Rezoning Petition Review

Rezoning Petition #: 08-66

Location of Property: Approximately 6.50 acres located on the northwest corner of N Tryon Street and WWT Harris Boulevard

**SITE PLAN/
TECHNICAL
DATA SHEET**

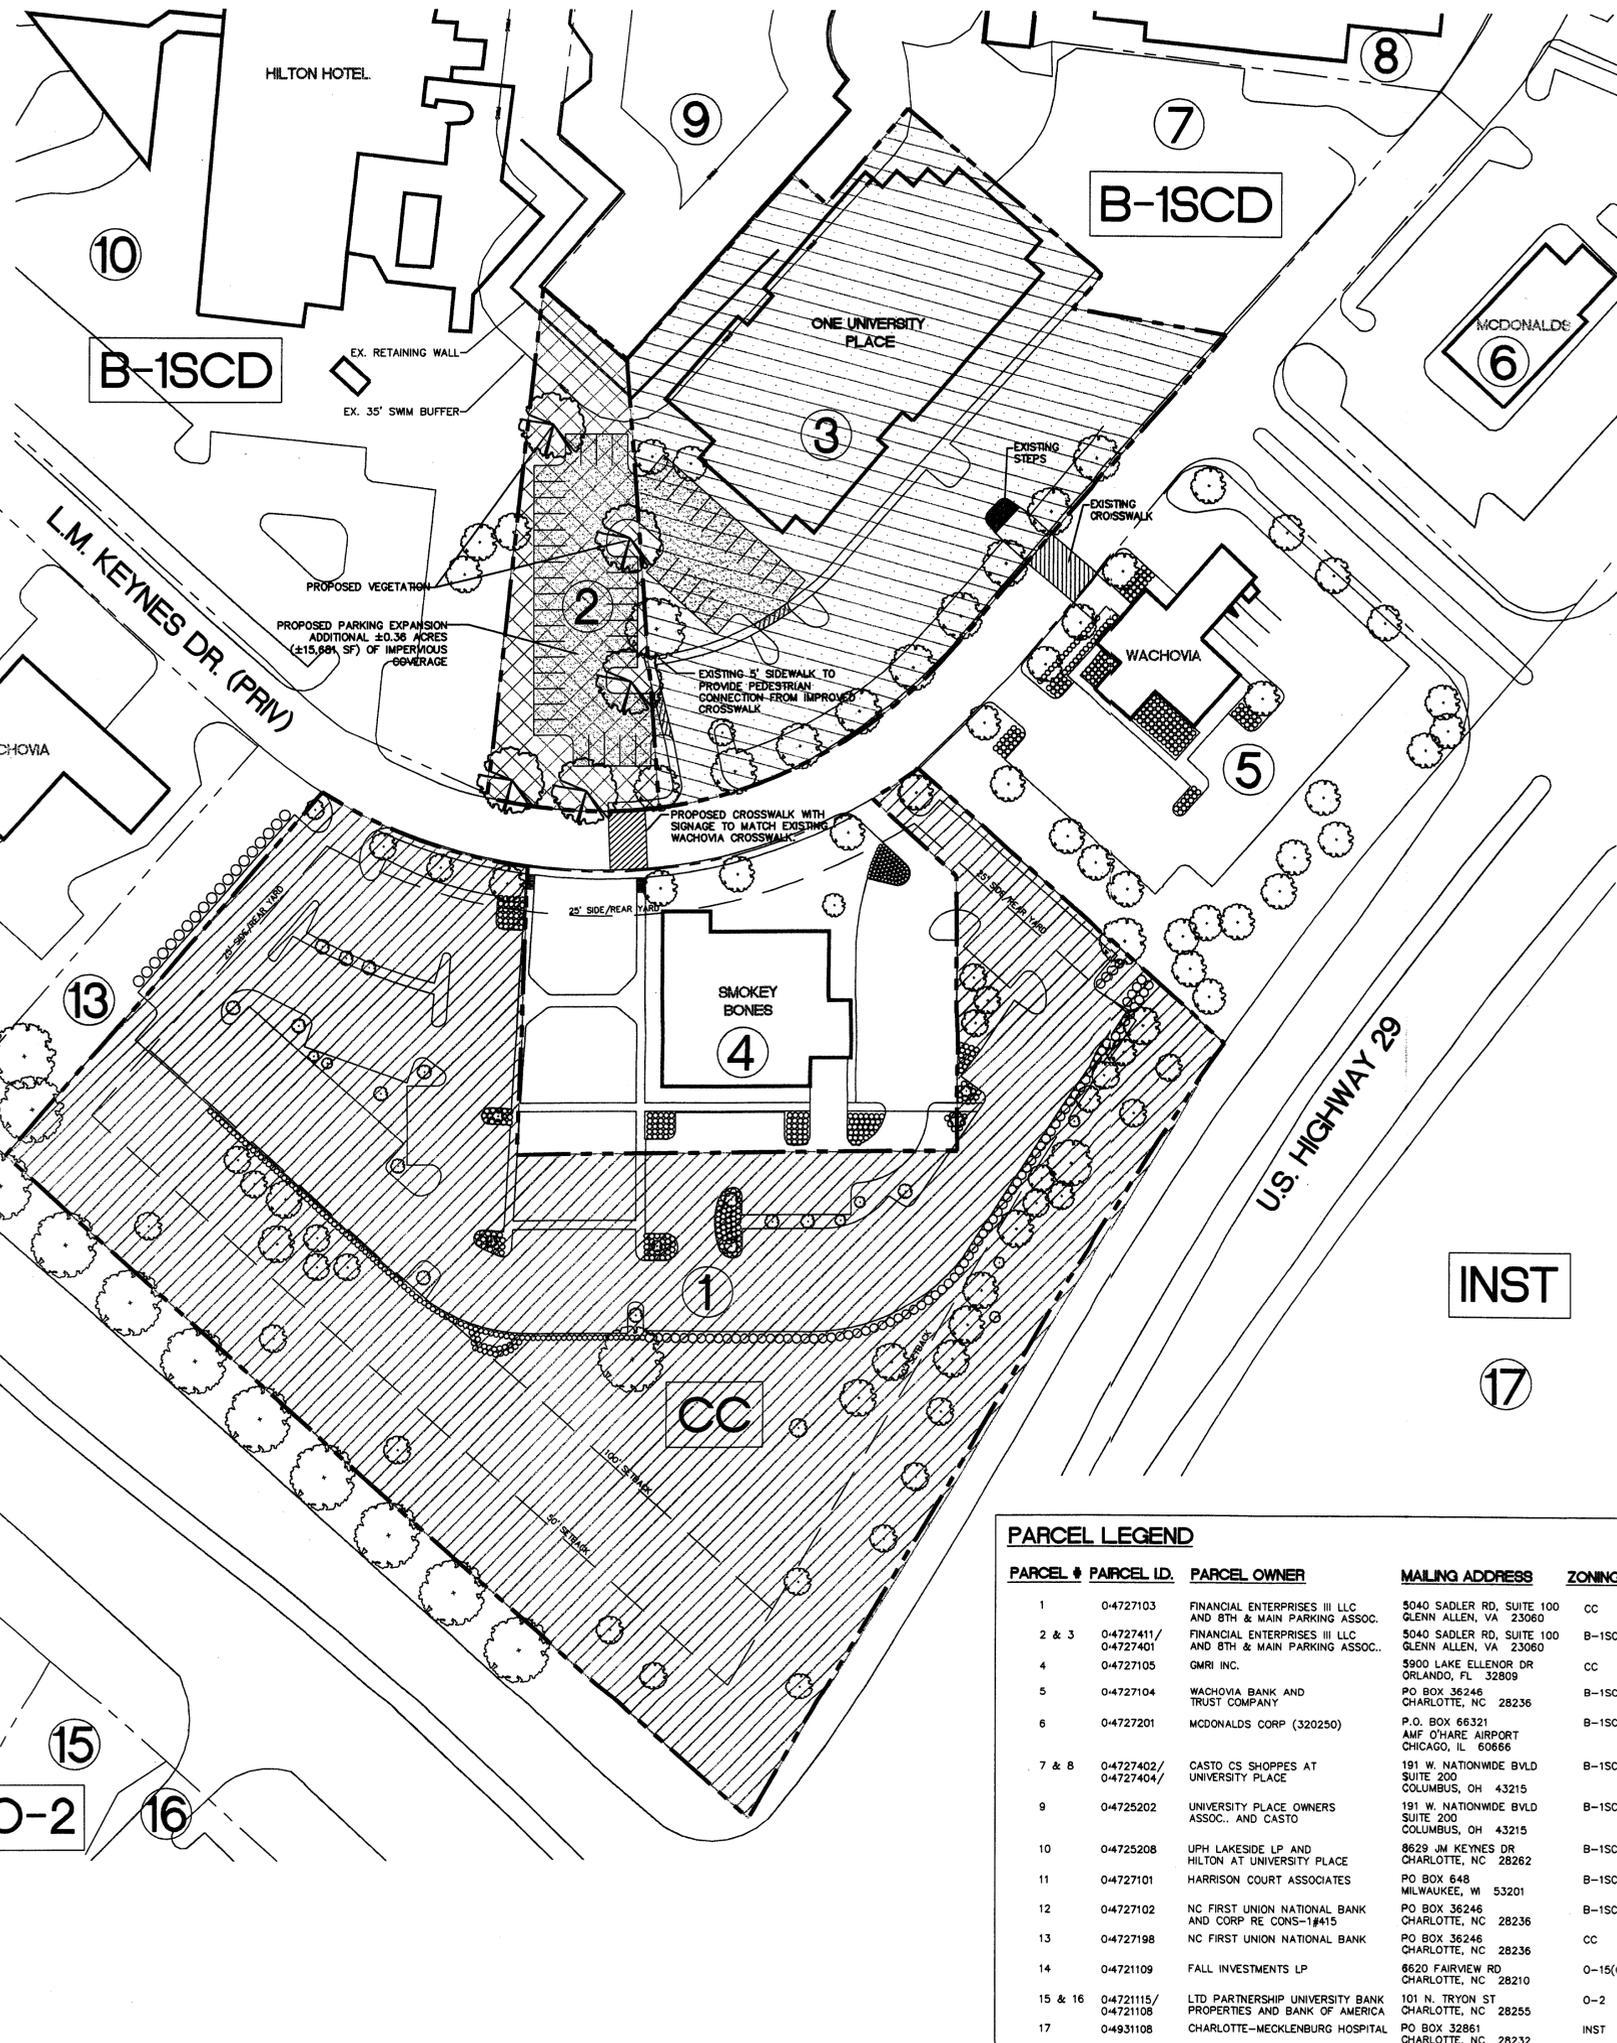
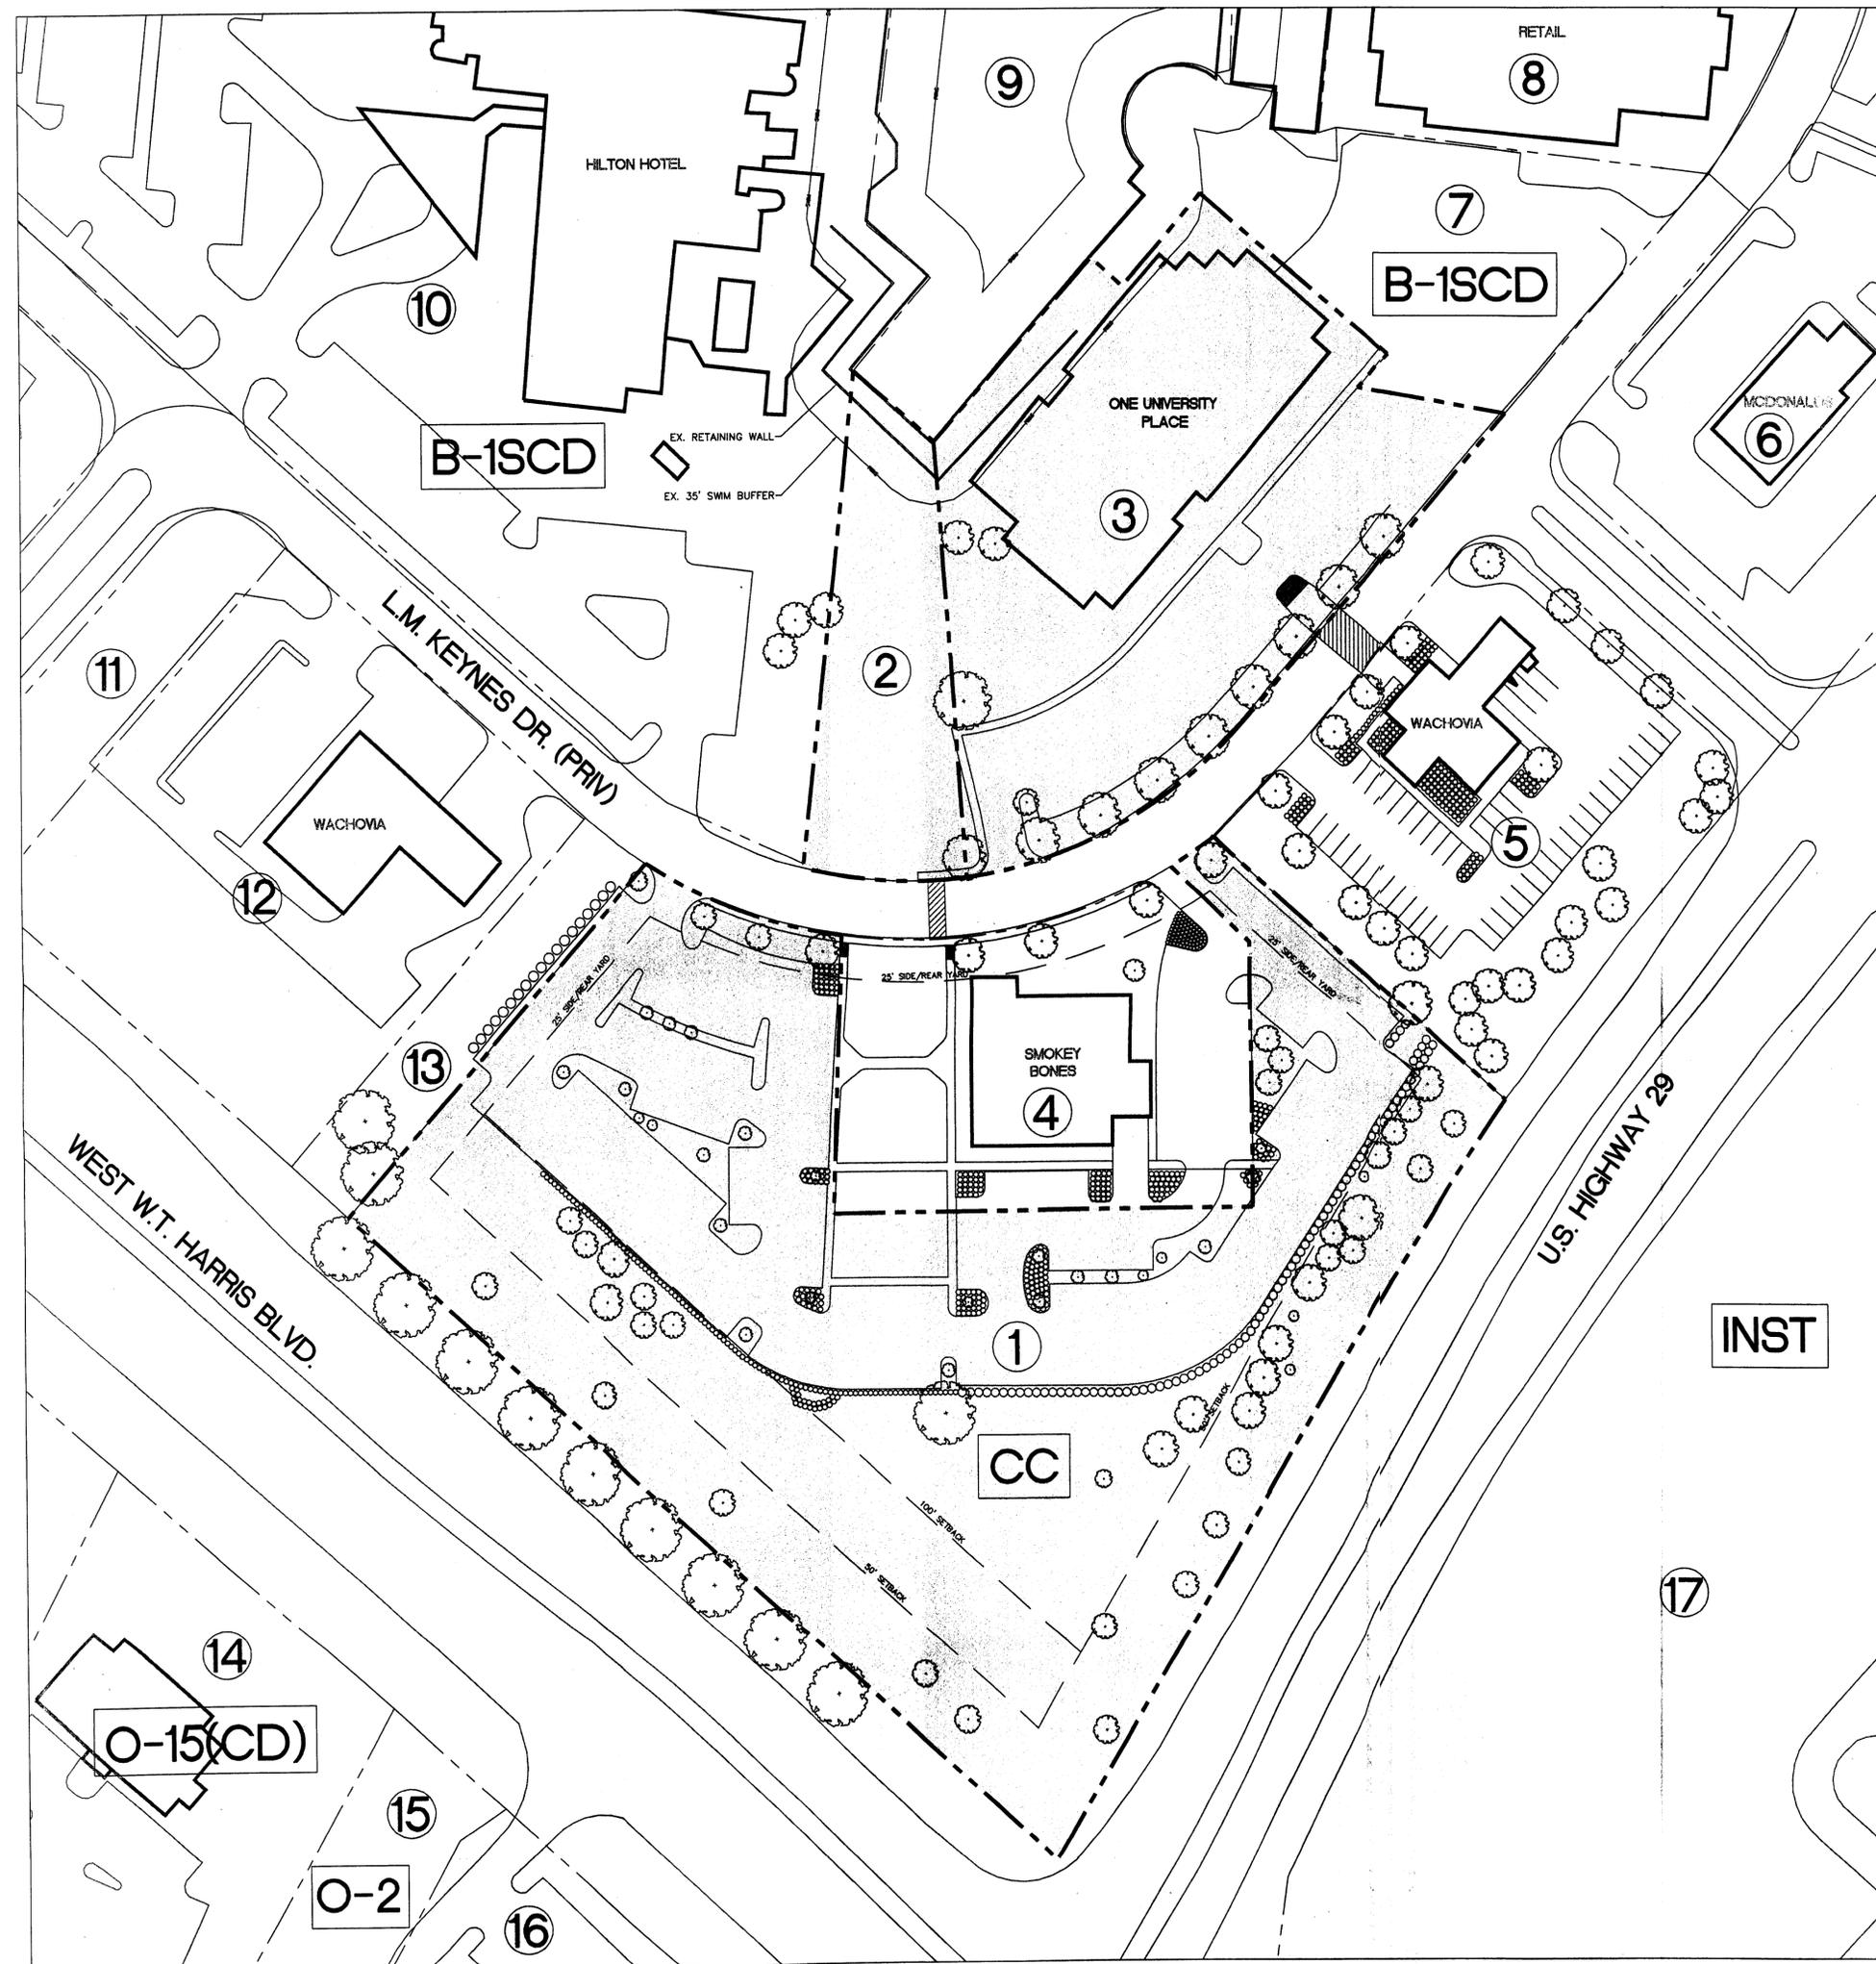
Downstream Complaints and analysis: This site drains to a stream listed as impaired by the NC Division of Water Quality.

Include the following notes on the petition.

The petitioner shall comply with the Charlotte City Council approved and adopted Post Construction Controls Ordinance.

Please Remove the Additional Statements and Include the following notes on the petition.

The petitioner shall comply with the Charlotte City Council approved and adopted Post Construction Controls Ordinance.
